CITY OF ALBUQUERQUE

December 15, 2025

**RE: Skyview West Warehouse Office
7110 Central Ave SW
30-Day Temporary CO Extension- Approved
Engineer's Stamp Date: 10/21/24
Engineer's Certification Date: 10/2/25
Hydrology File: K10D070
Case # HYDR-2025-00356**

ENGINEER'S SEAL  RONALD R. BOHANNAN P.E. #7868	<b>SKYVIEW WEST</b> <b>ALBUQUERQUE, NM</b>	DRAWN BY pm
	<b>GRADING PLAN</b>	DATE 10-21-24
 <b>TERRA WEST, LLC</b> 5571 MIDWAY PARK PL NE ALBUQUERQUE, NEW MEXICO 87109 (505) 858-3100 www.tierrawestllc.com	SHEET # <b>GR-1</b>	JOB # 2023062

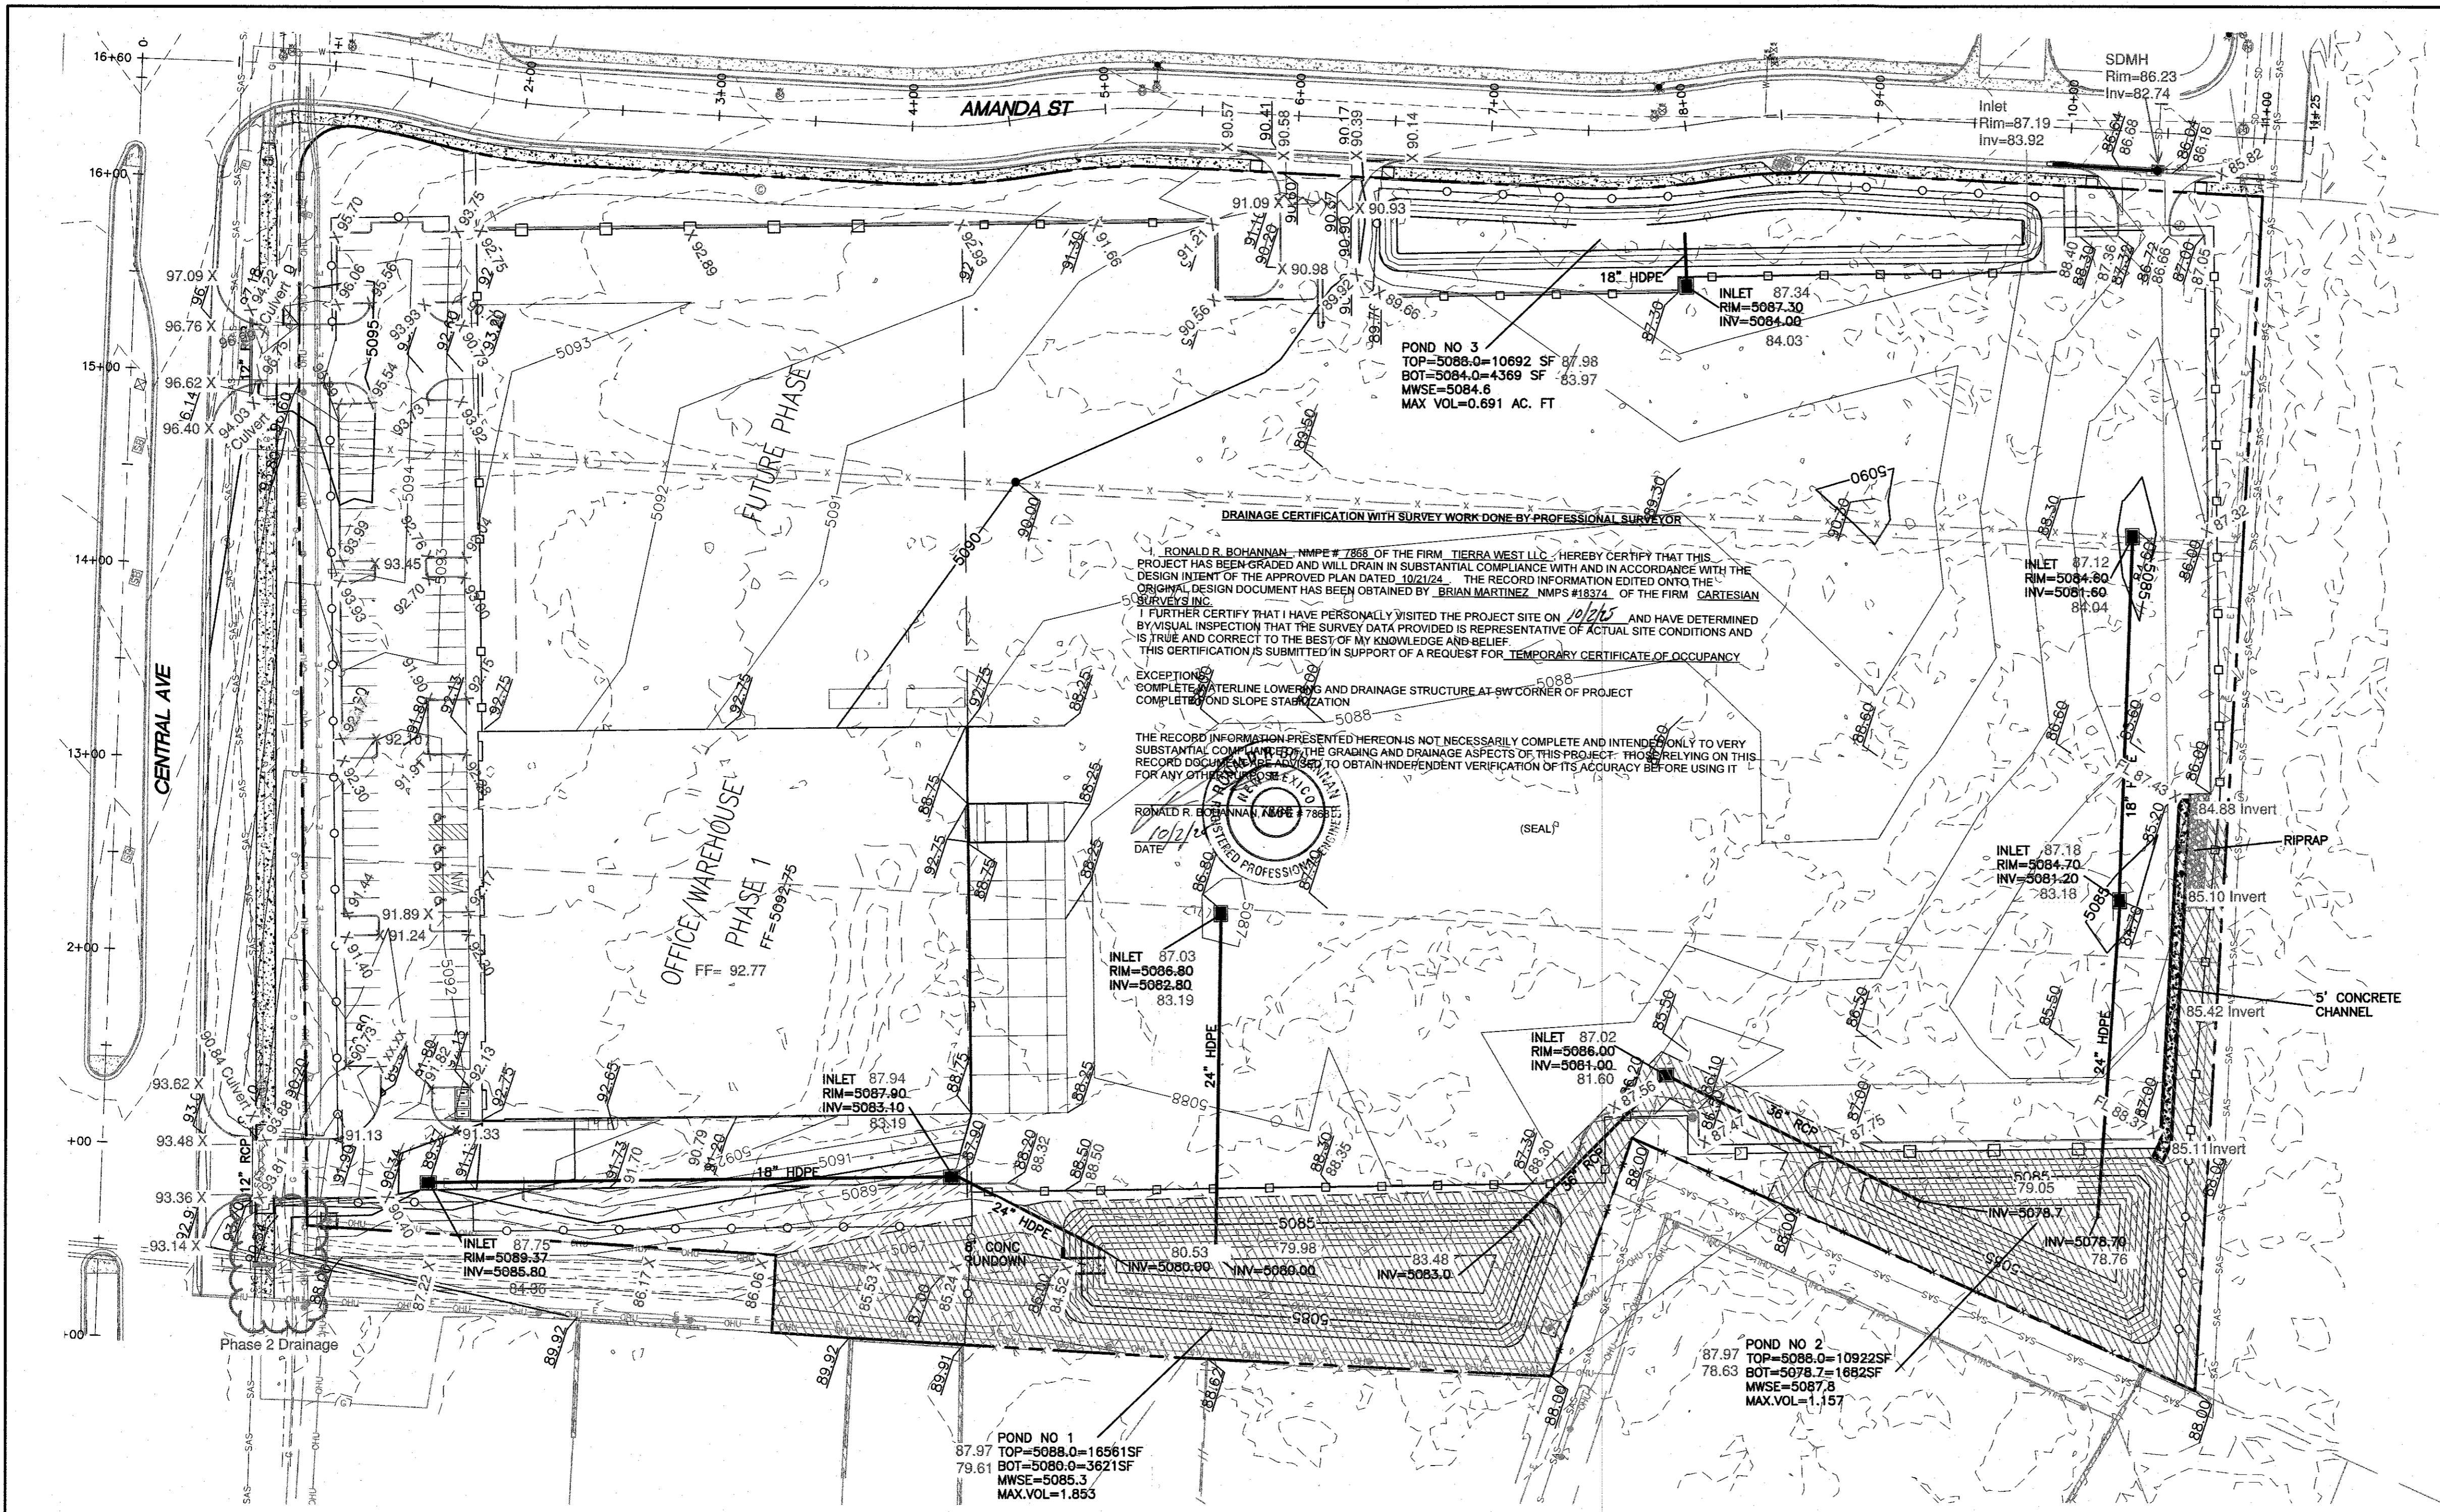
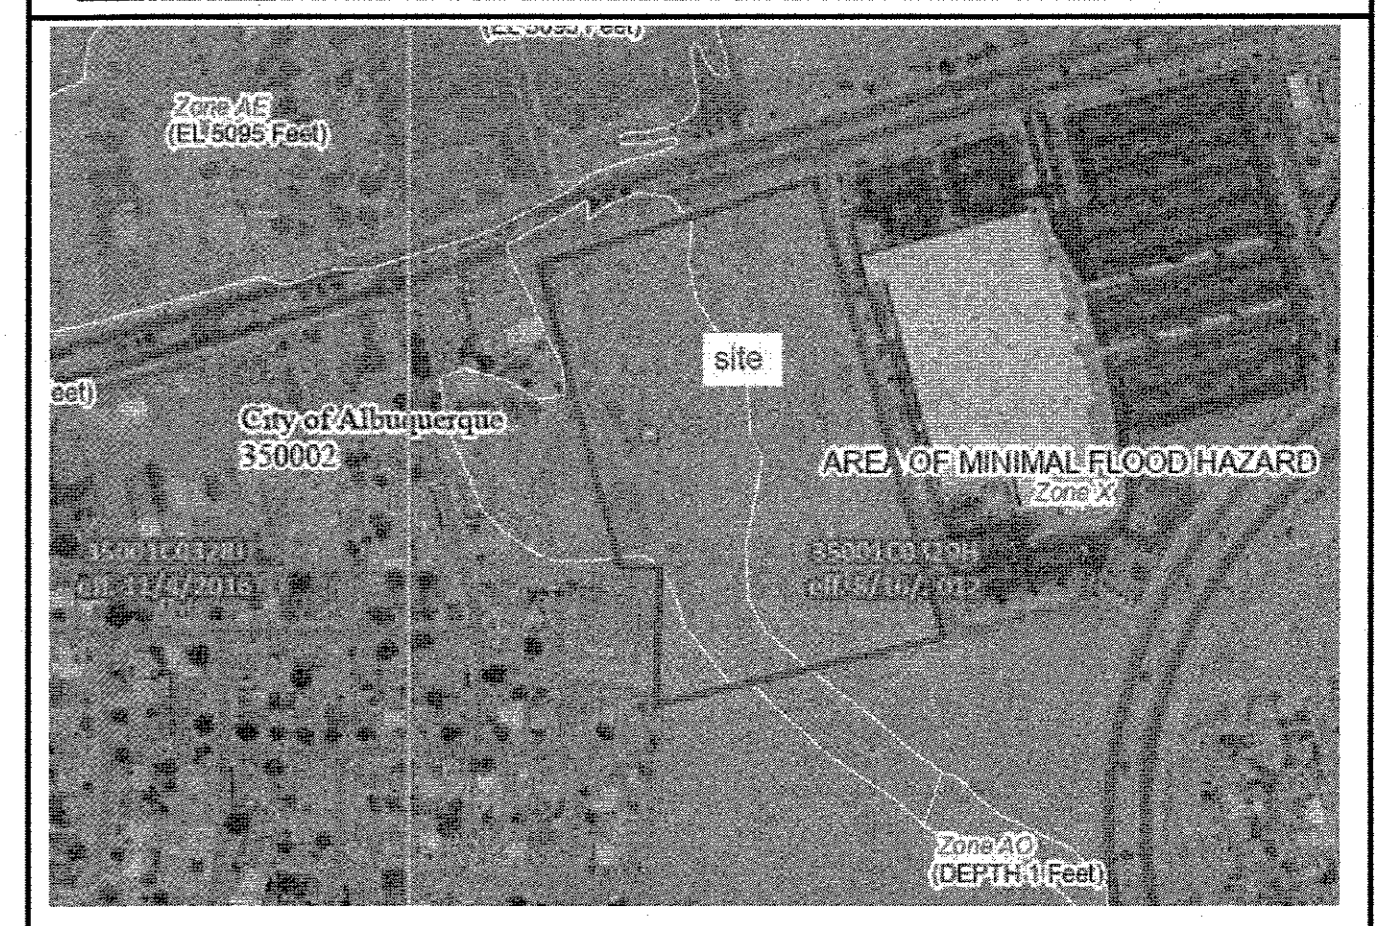
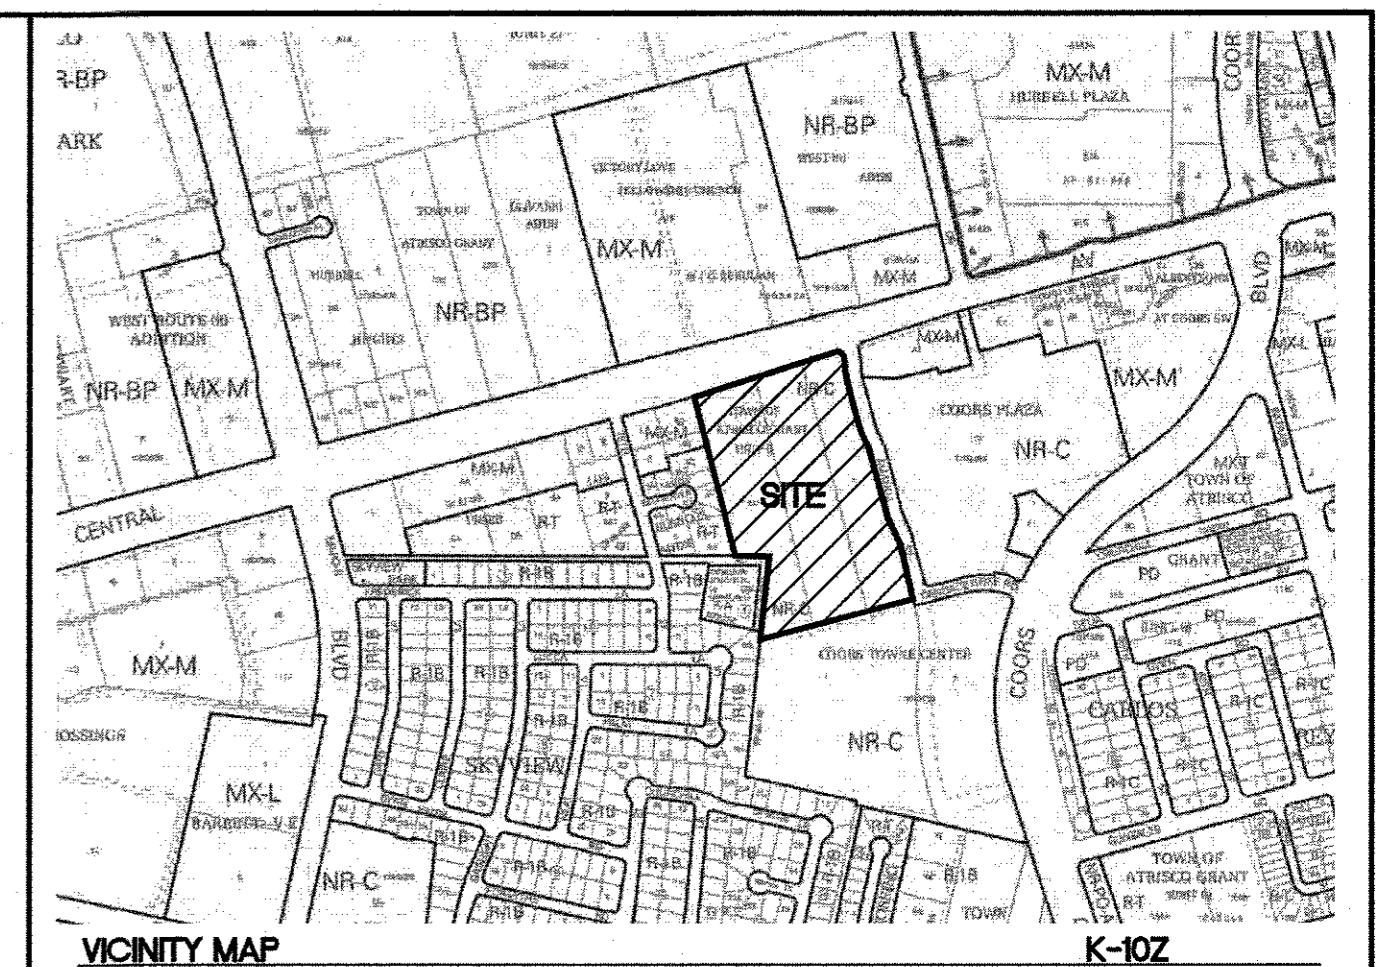
1. Complete the construction of the drainage structure NW corner of the project.
